Your Ref: OWQC3907
Our Ref: P/81/14/HH
Please ask for:
Mrs J Chapman

Wooden shed/garage at front of property.
Roselawn Seftor Road Bognor Regis

Thank you for your internet comments made on 19th September 2014 which has been recorded as 'an objection' with the comments as follows:

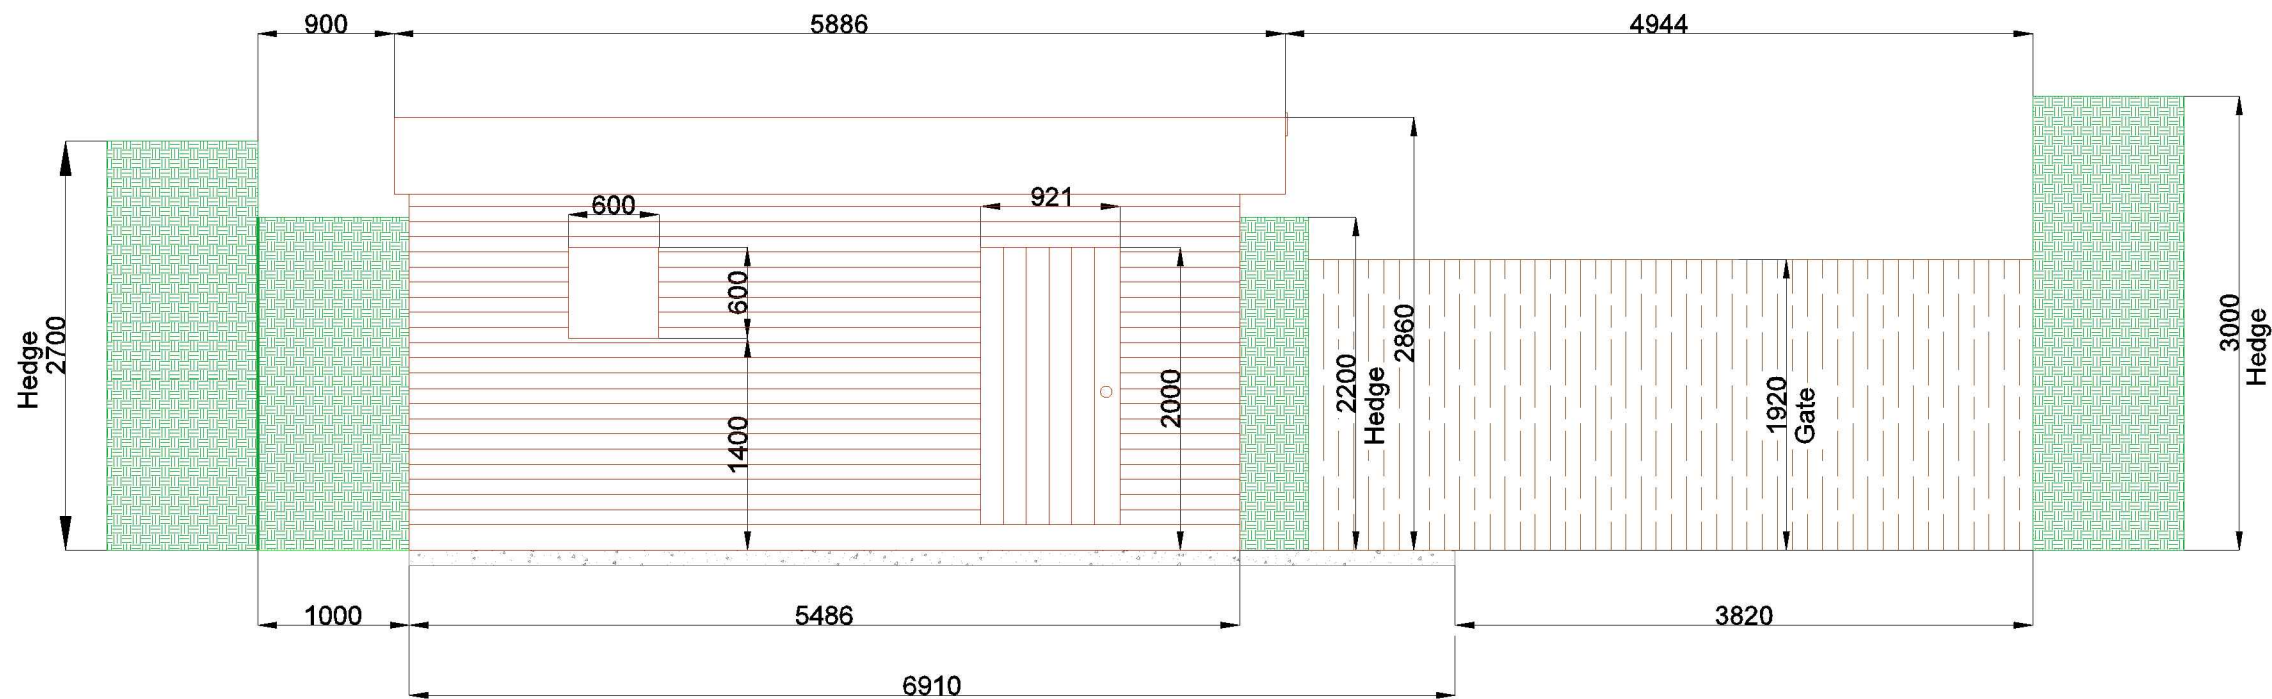
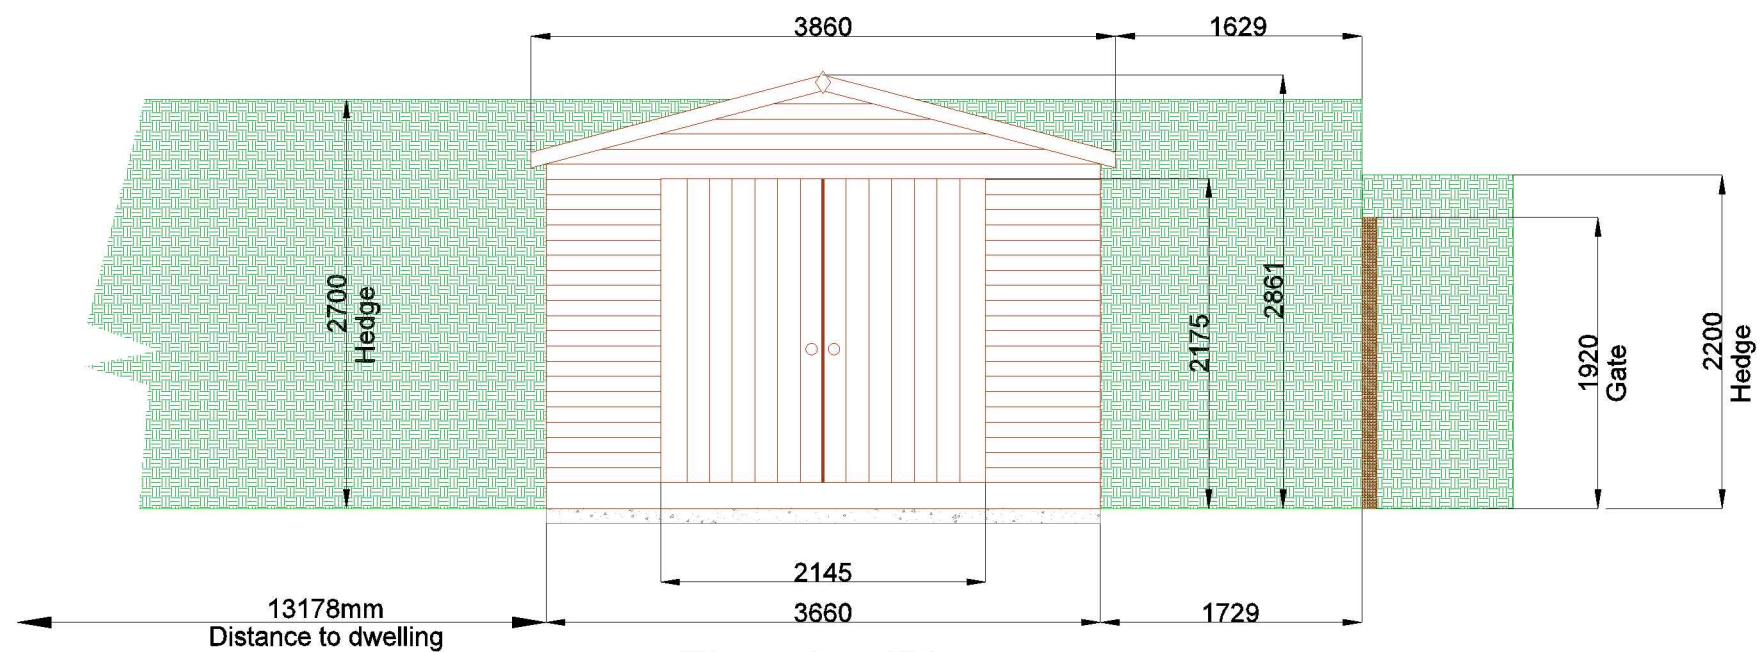
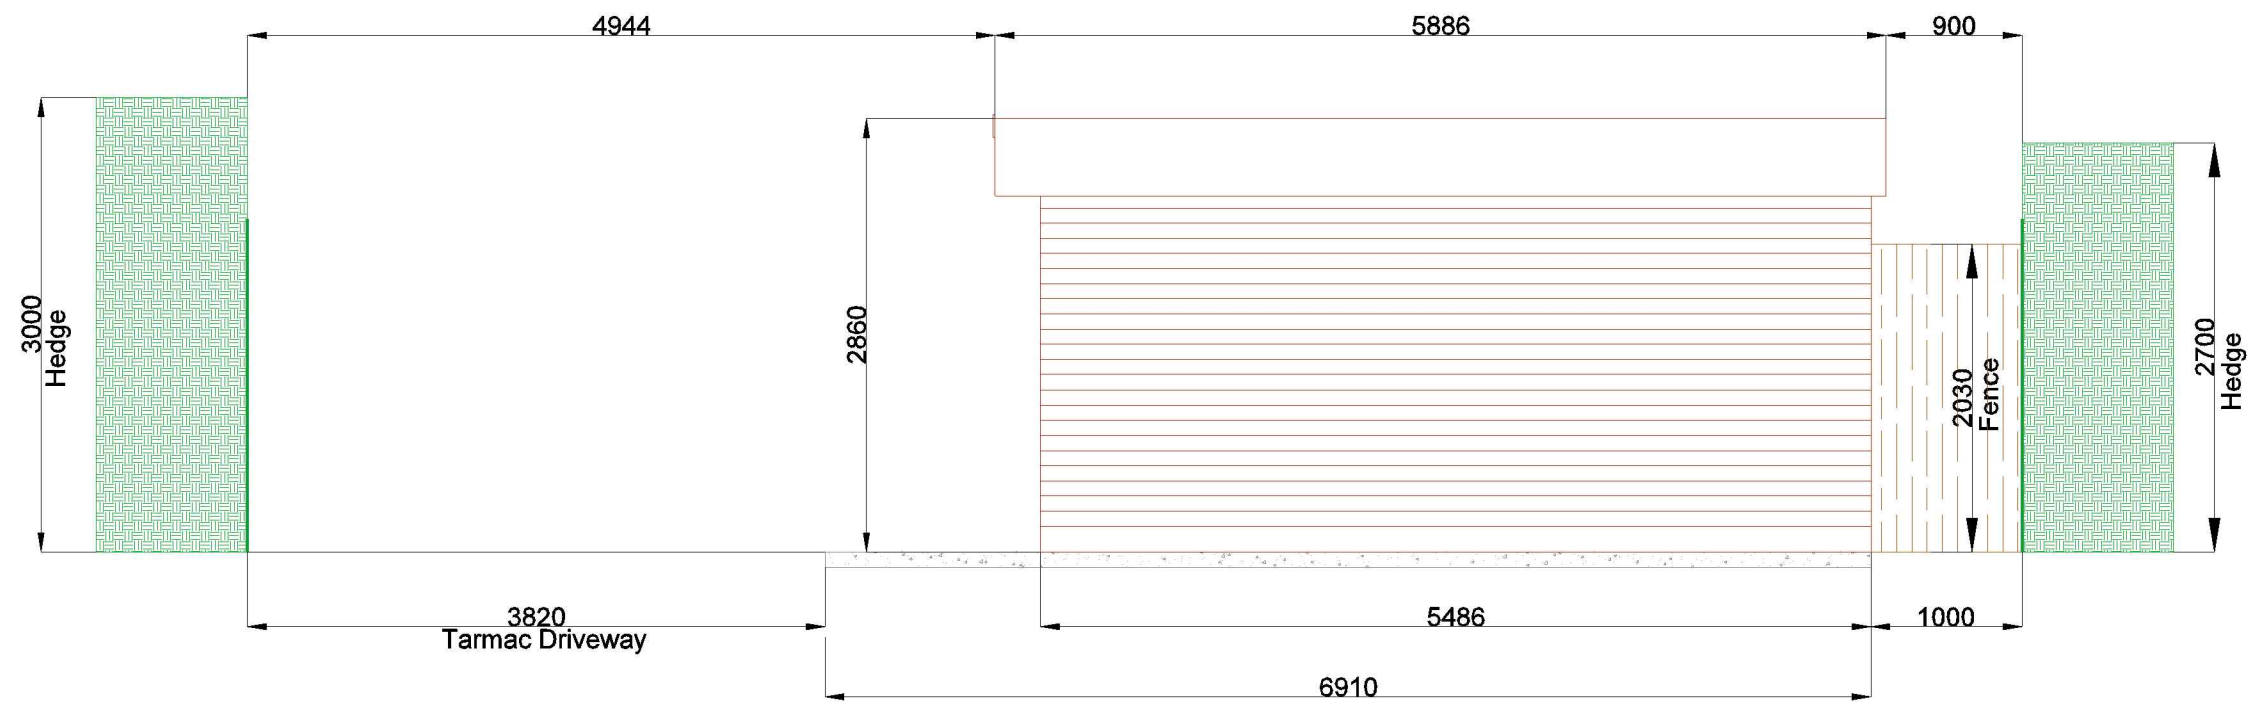
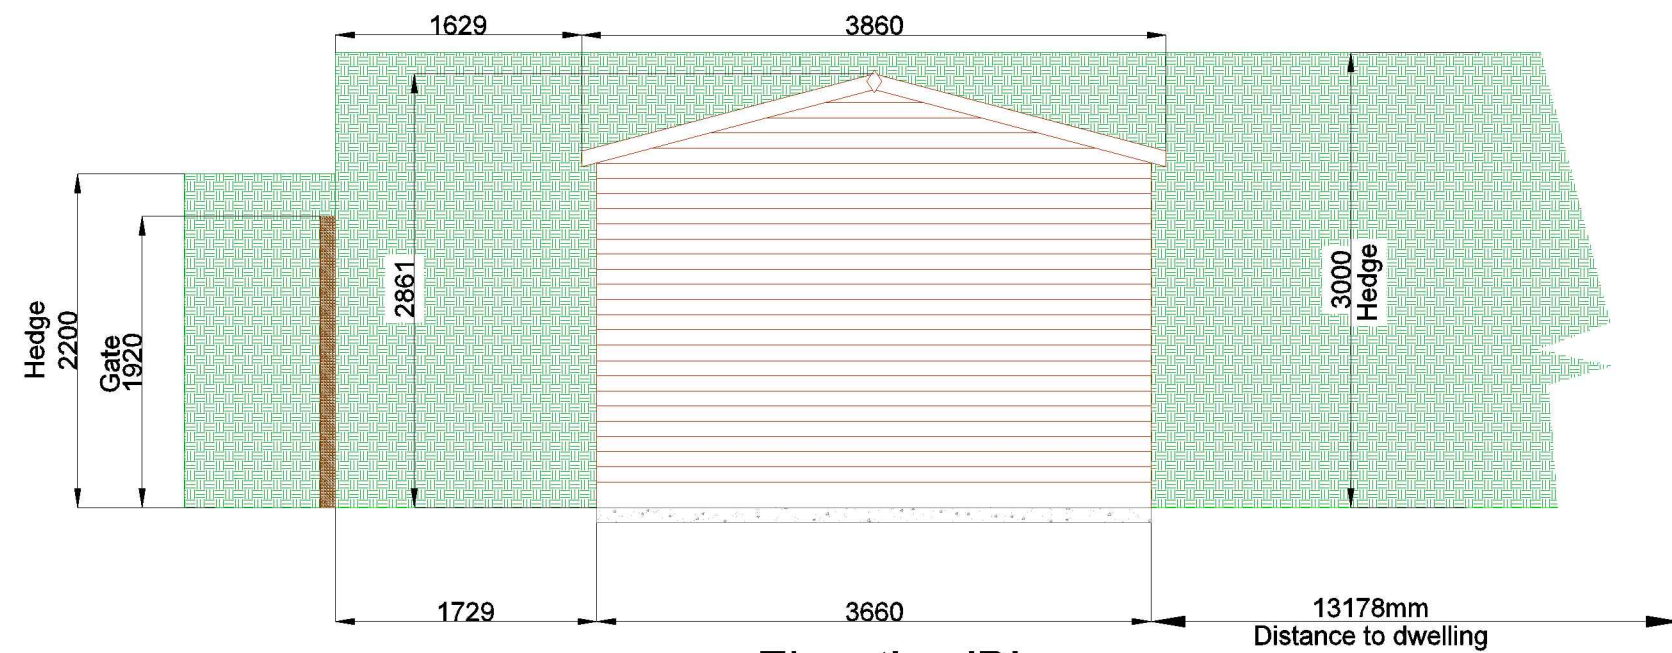
Members were concerned that such a development could promote similar applications by virtue of precedent. It was noted that the existing frontage comprised of high double gates and tall hedging. Some disparity in relative hedge and proposed building heights appeared to indicate that perhaps part or all of the structure might be found to benefit from roadside frontage screening.
